Reg No.: 16/0489

Application for approval of a controlled activity pursuant to s.183 Airports Act

Proposed Activity: PROPERTY DEVELOPMENT  
Location: COCKLE BAY WHARF, DARLING HARBOUR  
Proponent: NSW PLANNING & ENVIRONMENT

STAGE 1 DA APPLICATION SK-4.10

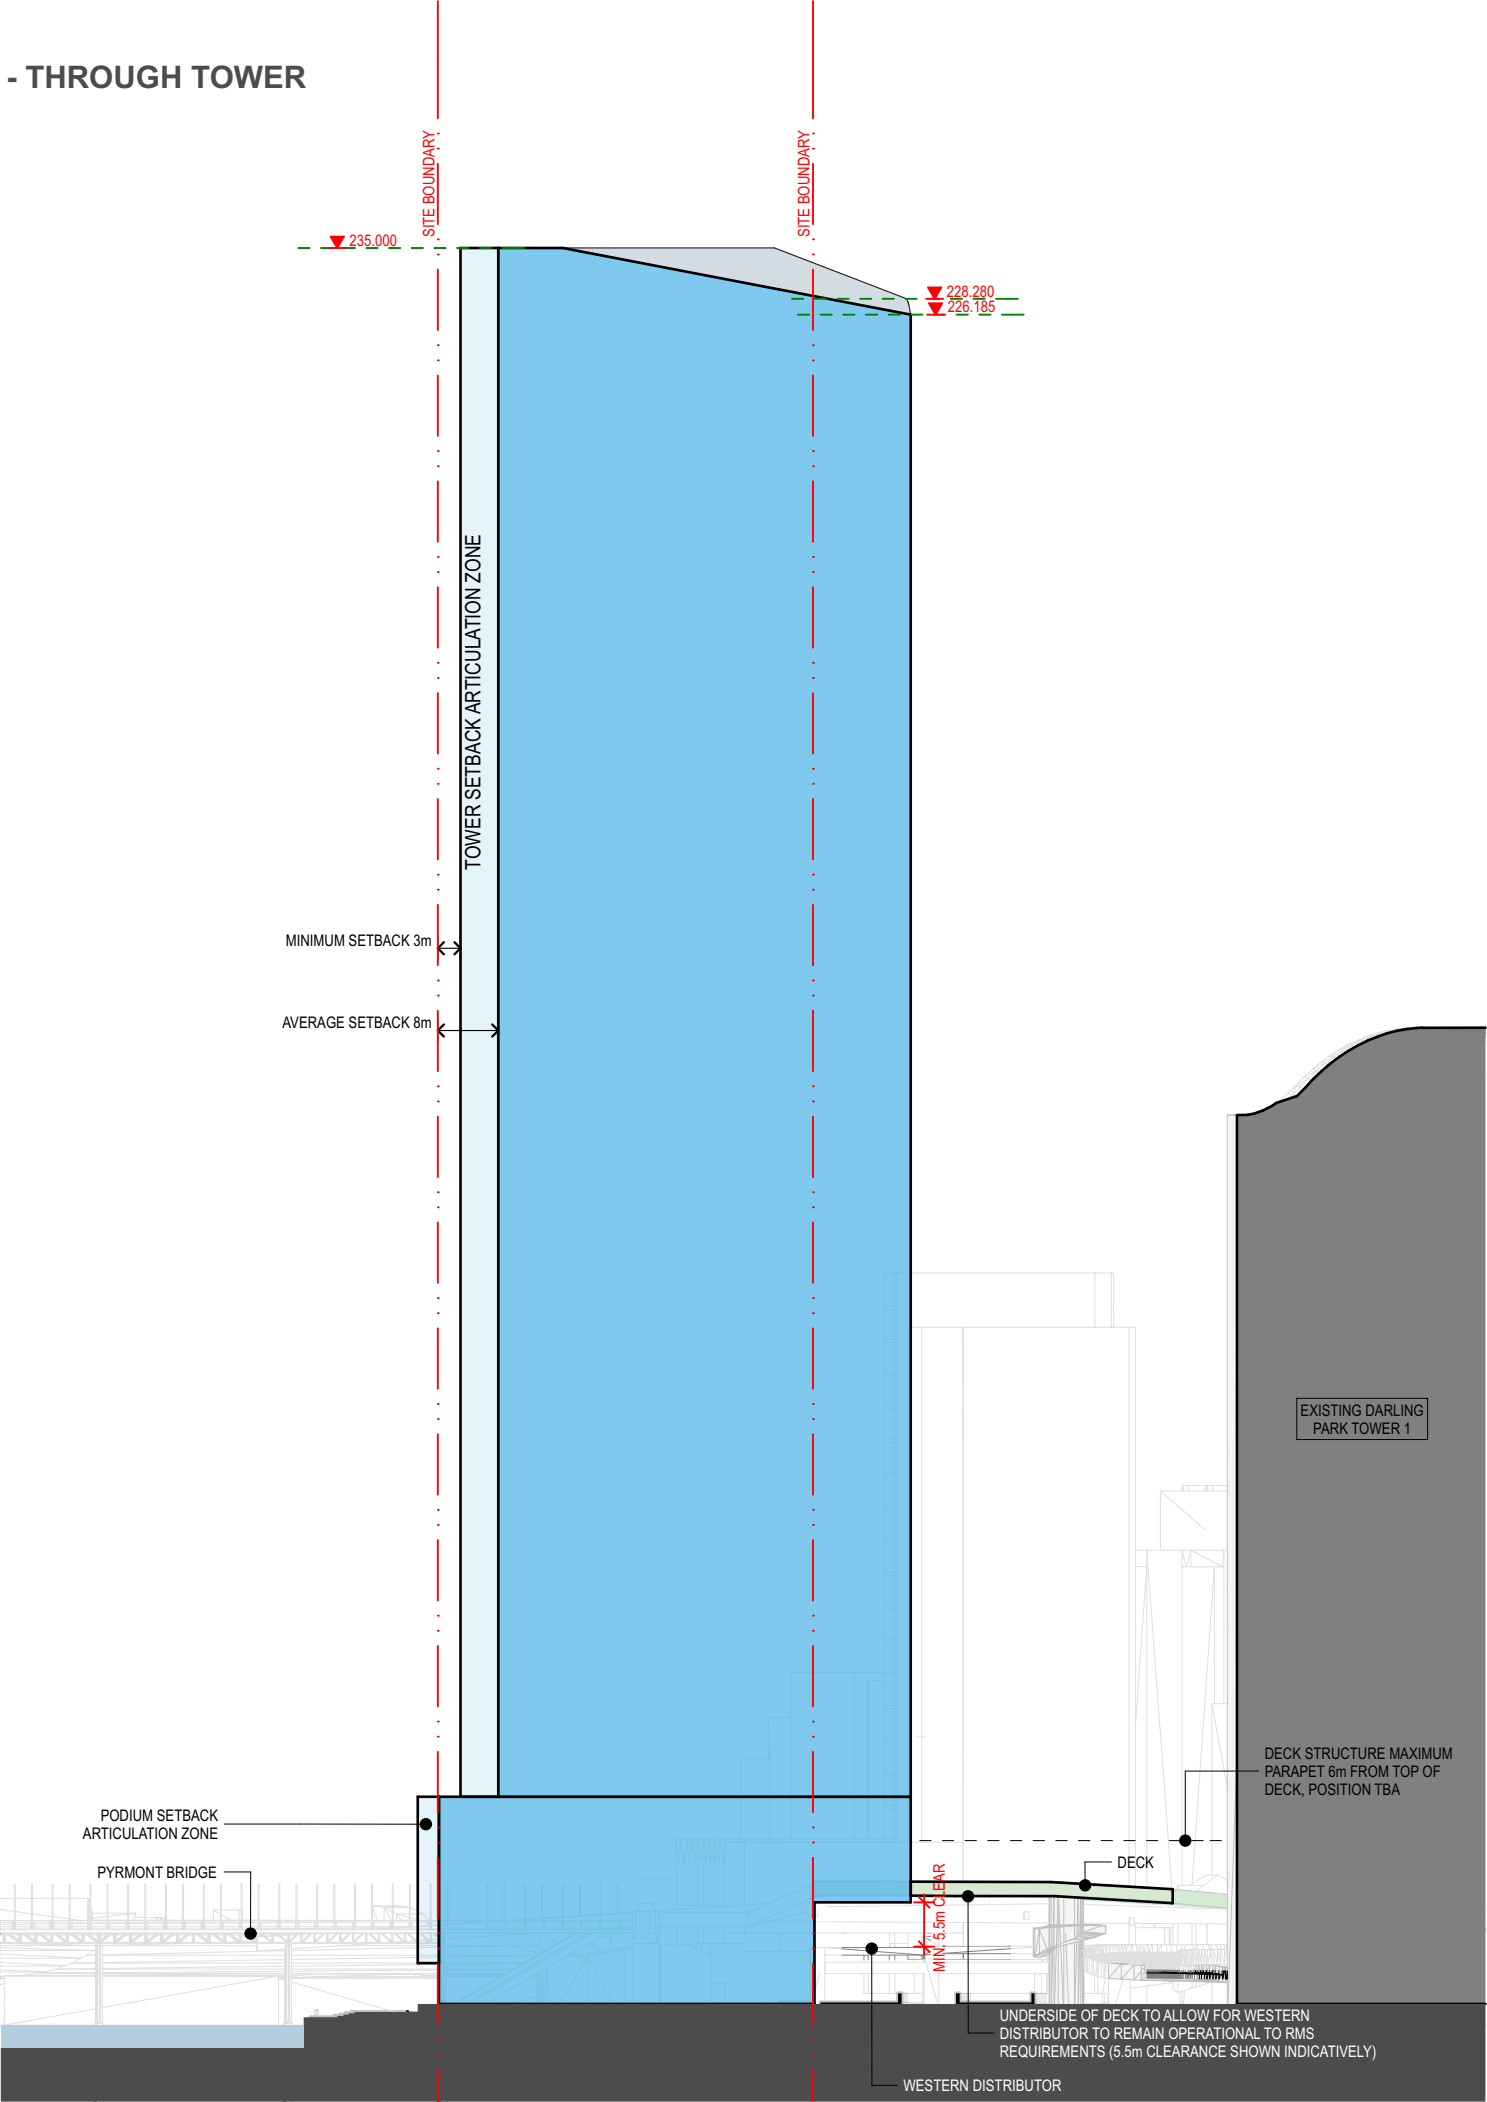
At a height of 235m AHD, the proposed development would penetrate the OLS by 79 metres.

Sydney Airport believes that at 332m AHD, Obstacle #5058 (centrepont tower) would shield the proposed development.

- The maximum height of the proposed development may not exceed 235m AHD, inclusive of all lift over-runs, vents, chimneys, aerals, TV antennae, construction cranes etc.
- At the completion of the construction of the building, a certified surveyor is to notify (in writing) the airfield design manager of the finished height of the building.
